2025/0675

Arley House, 13 The Green, Shafton, Barnsley S72 8PQ

Change of use of the existing dwelling into a 7 bedroom HMO

Drawing Title: As Proposed Plans

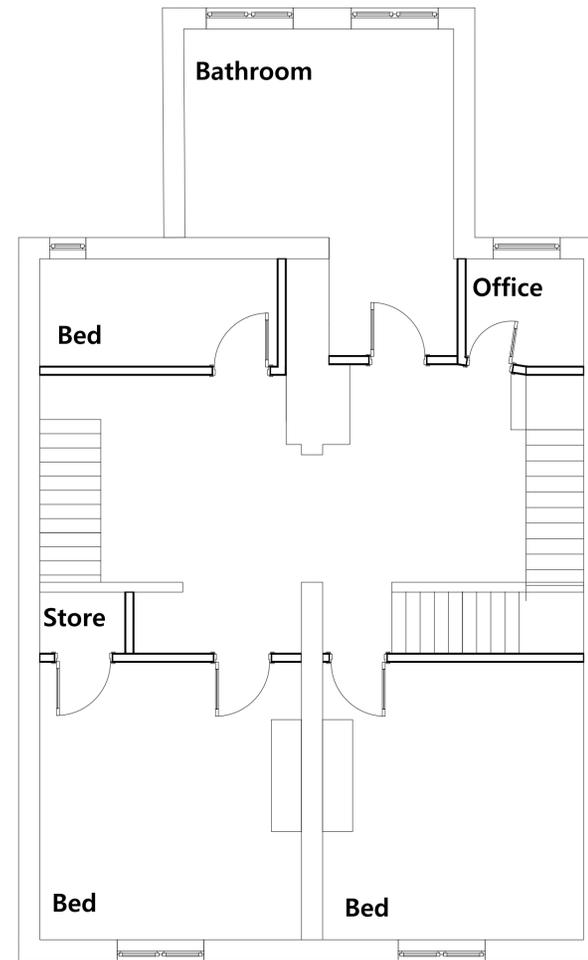
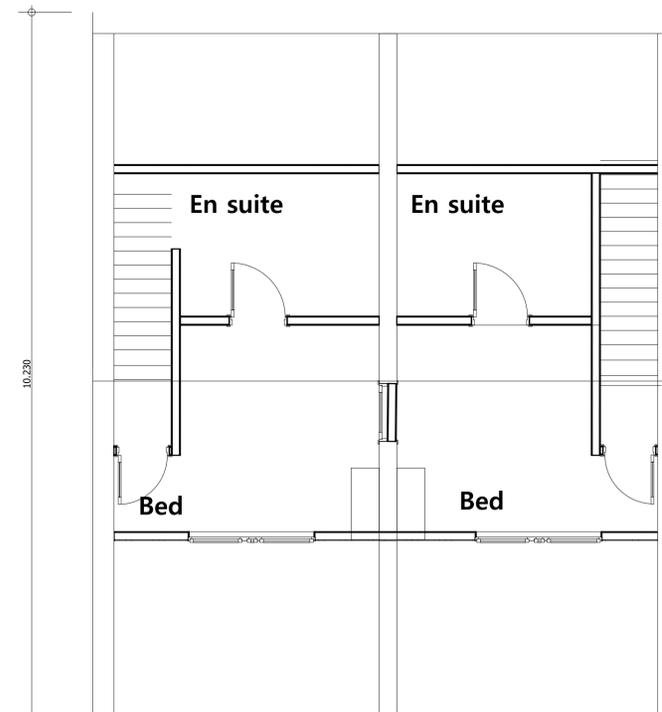
The proposal is for a 7-bedroom HMO. The SYRDG sets out the minimum acceptable internal space standards. The South Yorkshire Residential Design Guide states that the minimum size should 12sqm for a double bedroom or 7sqm for a single bedroom. The proposed floor plans indicate that one of the proposed bedrooms does not meet the minimum space requirements being only 5sqm.

The South Yorkshire Design Guide also states that the minimum bathroom size should be 3.5sqm, the en-suite falls short of this requirement however the proposed communal bathroom exceeds this requirement. The kitchen also falls short of the 16sqm requirement, being only 11.5sqm.

The SPD also goes on to state that the external amenity space should be at least 60m². The proposed site plan shows a substandard private rear amenity space to the rear with three parking spaces taking up the majority of the garden.
